**From:** Christina Stacey  
**To:** zcharles24@gmail.com ; zcharles@unum.com  
**Date:** 9/2/2015 1:49 PM  
**Subject:** Re: Fwd: Garage permit status

Here are the questions I need answered to complete the zoning review:

I do not mean to be a pain but I am writing to check on the status of my garage permit for Zach Charles @ 58 Gertrude Ave. I believe I submitted my plans for a permit 7/7 and the web site says I am in pending status.

Plot Plan

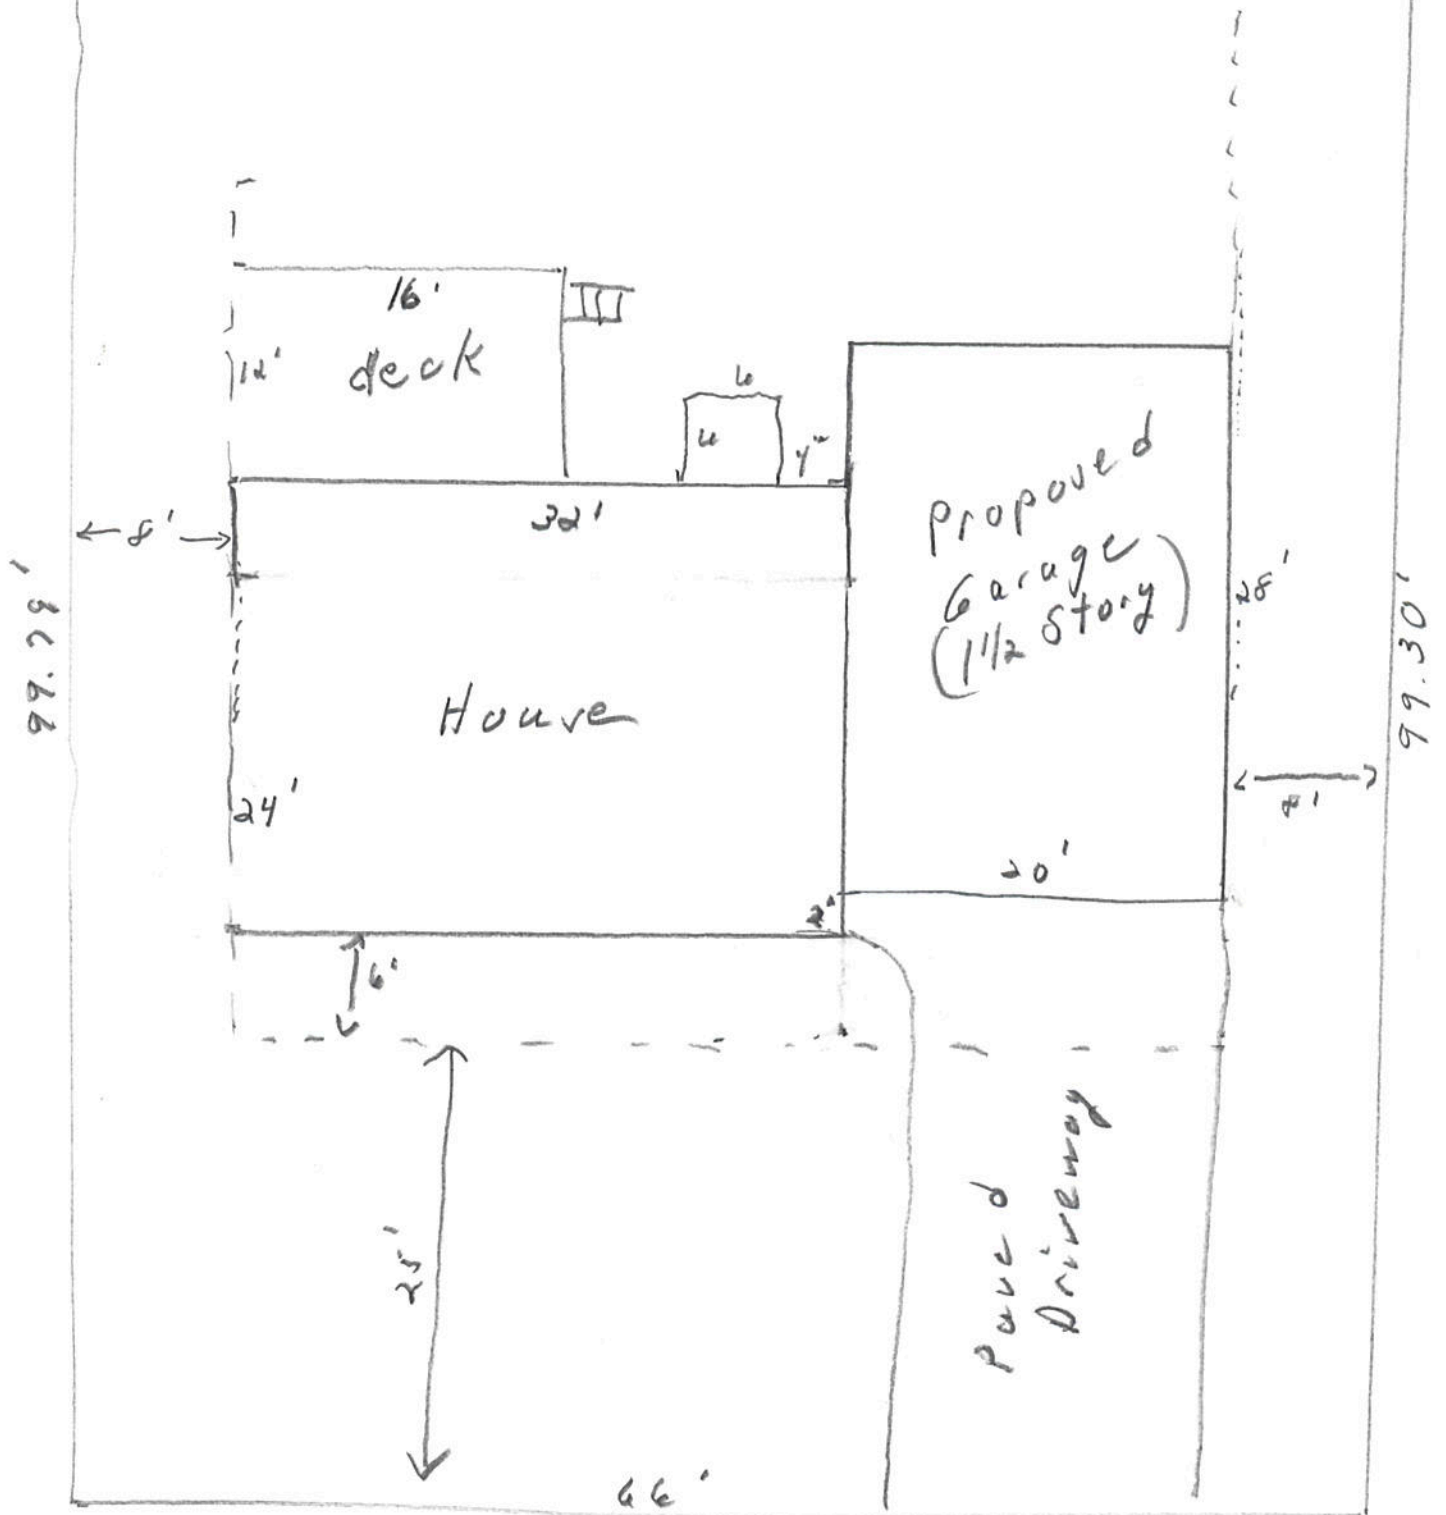
- 1) On the plot plan, there is a dotted line running parallel to the front of the house that measures 6' from the house. Can you clarify what this is - just a walkway or something else?
- 2) Can you e-mail me a PDF sketch of the proposed floor plan for the 1/2 story above the garage, including any partitions such as rooms, kneewalls, etc.?
